August 24, 2018

Re: MMC Staff Parking Garage | 222 St. John Street | Level III Site Plan  
Response to Public Comments 2

Thank you for coordinating the review of the Maine Medical Center Parking Garage project located at 222 St. John Street. This letter provides a summation of our responses to the comments received from various reviewers as part of the Level III Site Plan process. We have repeated the original comments in italics below, and our response follows each.

TYPICAL HYDRANT ASSEMBLY DETAIL
N.T.S.

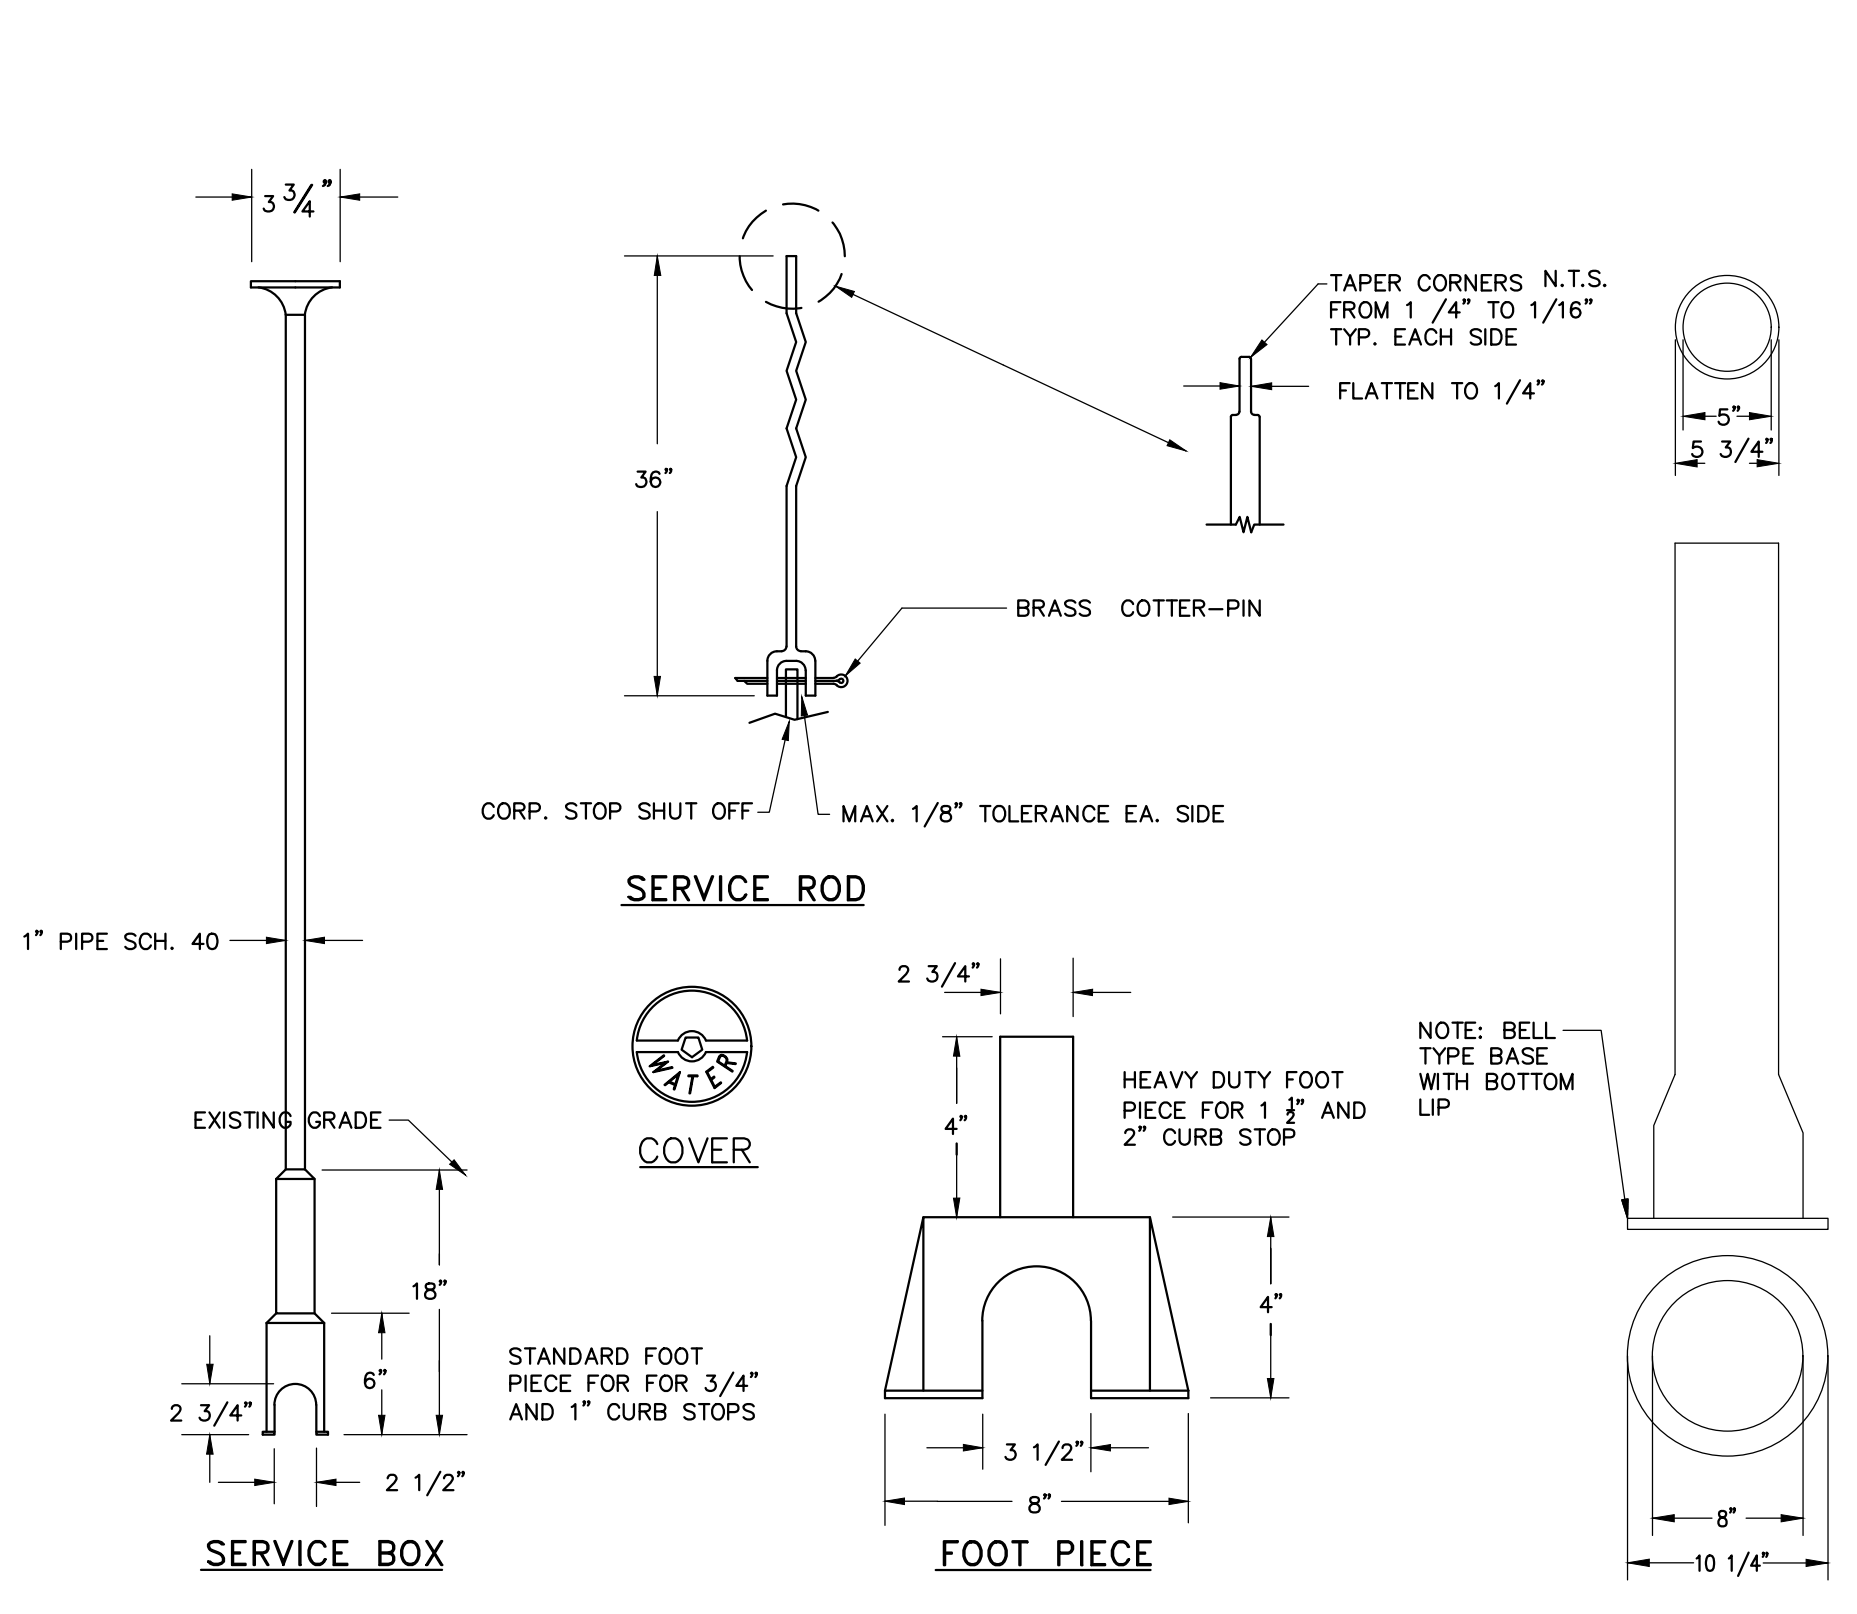
1. *The only item that still is of concern is the location of the private hydrant. We'd like to have it moved further west, between the access road into the lower garage entrance and surface parking lot. The proposed location doesn't give us easy access for operations covering the majority of the building.*

**Response:** The enclosed plans depict a revised hydrant location as recommended by the Fire Department.

GRADING & DRAINAGE PLAN - 2

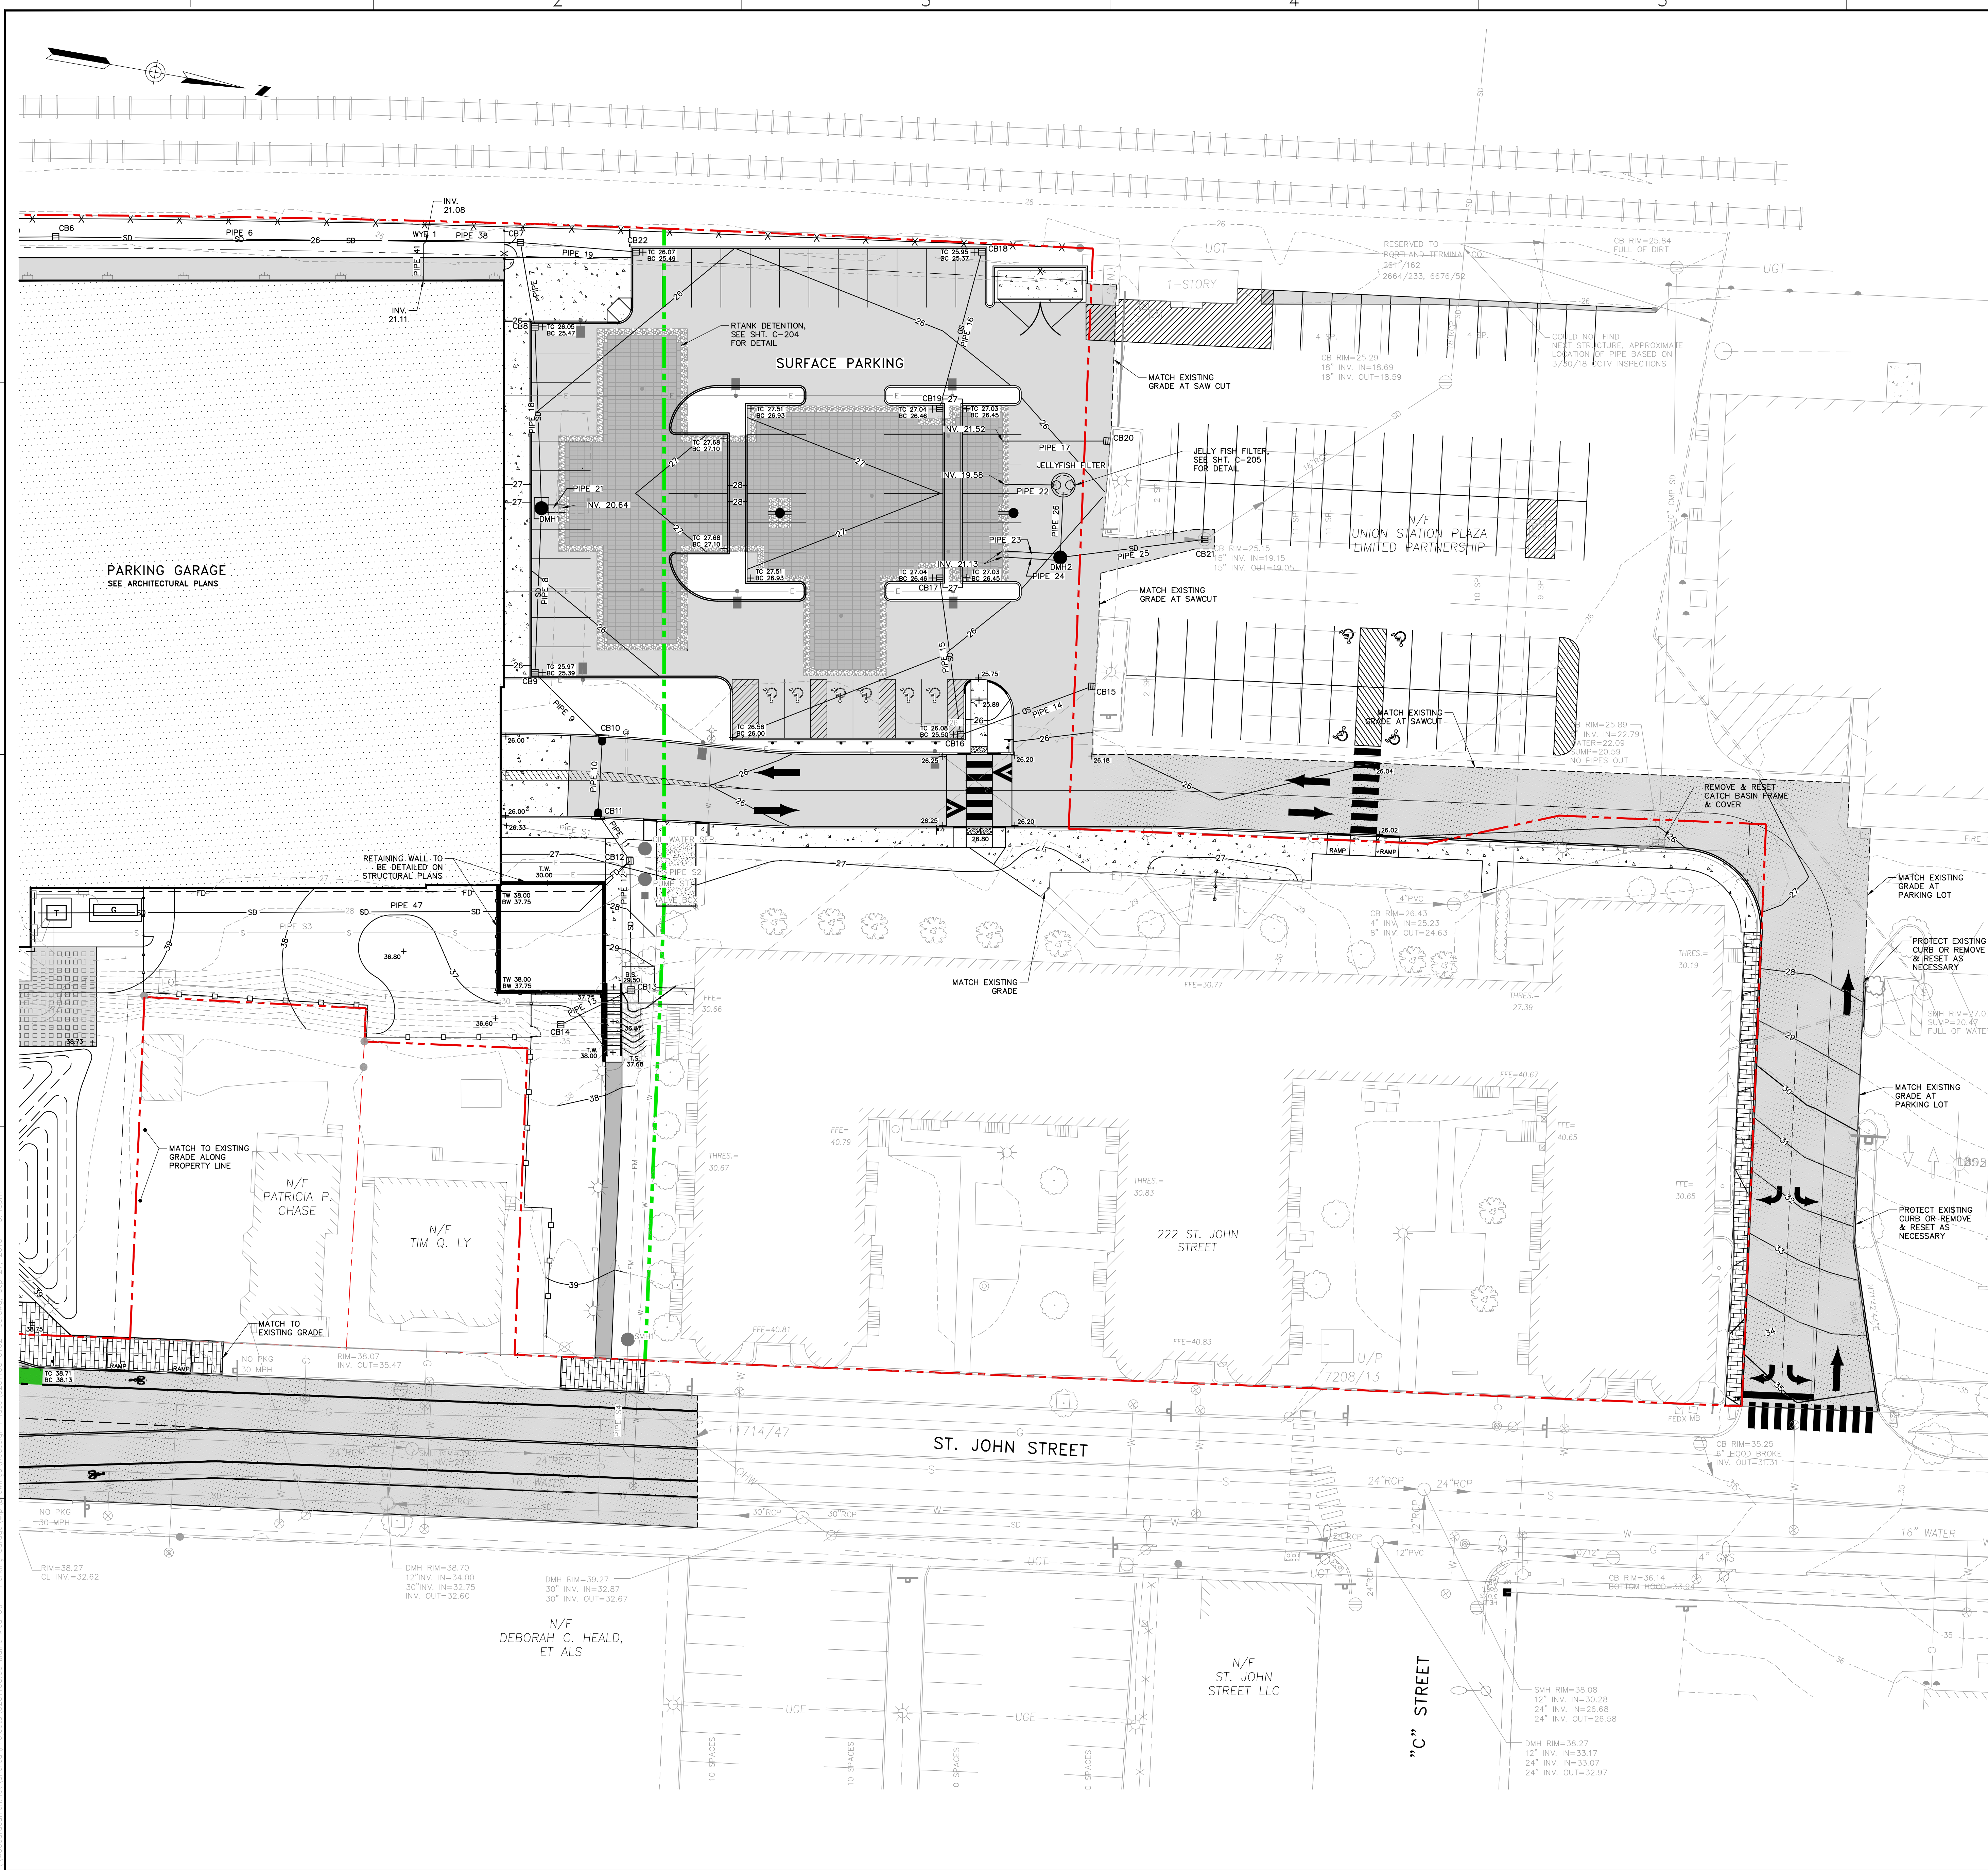
b. *Grading review identified that Pipe 14 between CB15-CB16 has a negative slope. Please revise or provide explanation.*

c. *Top of curb and Bottom of Curb information at CB-18 appears to be inverted. Please revise or provide explanation.*

**Response:** The pipe slope and associated invert elevations have been modified in the attached, revised plans.

**Response:** These elevations has been modified in the attached, revised plans.
